Householder Delegated Report

Application No.	23/02174/F
Site Address	Rosemary Cottage, Somerton Road, North Aston, OX25 6HX
Proposal	Replacement windows to annexe at Rosemary Cottage; door with glass side panels to be fitted with a new aluminium floor rail, added bottom rail/false bottom rail and security lock/handle
Amended Plans	None received

Subject:	Measure:	Date:	Rev. date:	Drawingnr.:
Proposed window Plan section A52/53/57	1:5	20.10.2023	-	1.031/N 02

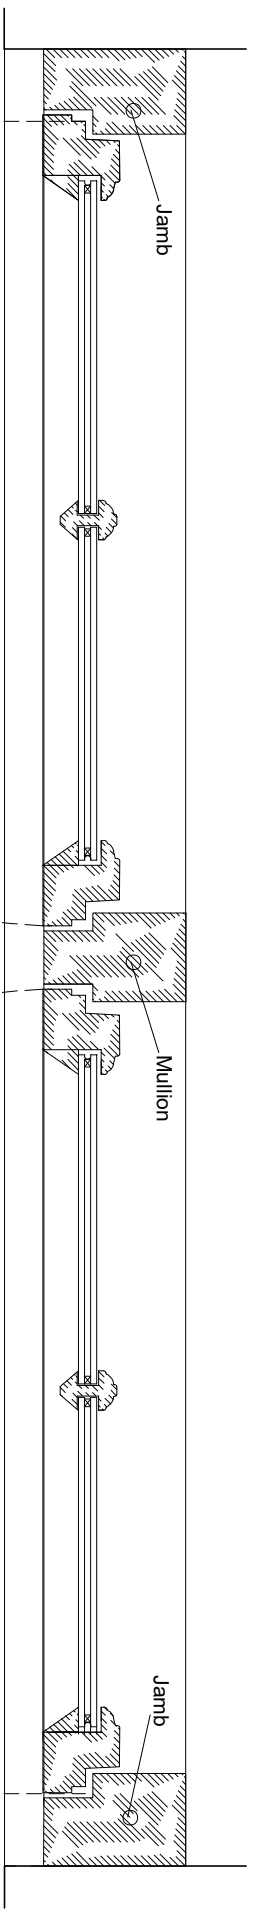
<ul style="list-style-type: none"> • Further information has been submitted which does demonstrate that the proposed windows would have true integrated glazing bars, would be flush fitted and would generally be traditionally designed and detailed. • However, it is still proposed to have double glazed units as opposed to single glazing. As commented previously double glazing is usually only ever acceptable when there is a visual benefit to the listed building and there does not appear to be a real benefit to the listed building in this instance as the existing window designs are not necessarily inappropriate or harmful in their design. • As such, although the proposed windows would appear to be traditionally designed, it is the double glazing itself, and resulting visual appearance/impact, where there are concerns. This is because double glazing can give double reflections and appear non-traditional, resulting in a visual disparity. • Consequently, it is considered that there would be a low-level of less than substantial harm to the heritage asset.

Comments (if any): CDC Conservation have objected to the proposal as outlined above – design OK but potential for window glare.

The Planning Officer agrees with the Conservation Officer in that a low-level of less than substantial harm to the heritage asset would occur from the installation of the proposed windows. However, the Planning Officer disagrees with CDC Conservation that the double glazing itself and any double reflective glare resulting in modest visual appearance/impact would of itself be sufficient to substantiate a reasonable objection to the proposal and would not result in a substantive visual, non-traditional disparity.

The applicant has indicated that the windows would be manufactured in a suitable hardwood, with thin Pane double glazing units, Putty Beads/Ovolo glazing bar. Fitted with washer butt hinges, multi-lock furniture and trickle vents to help ventilate the building.

Such windows are considered appropriate in this case. They would allow the building to continue to be used for residential accommodation with improved energy efficiency.
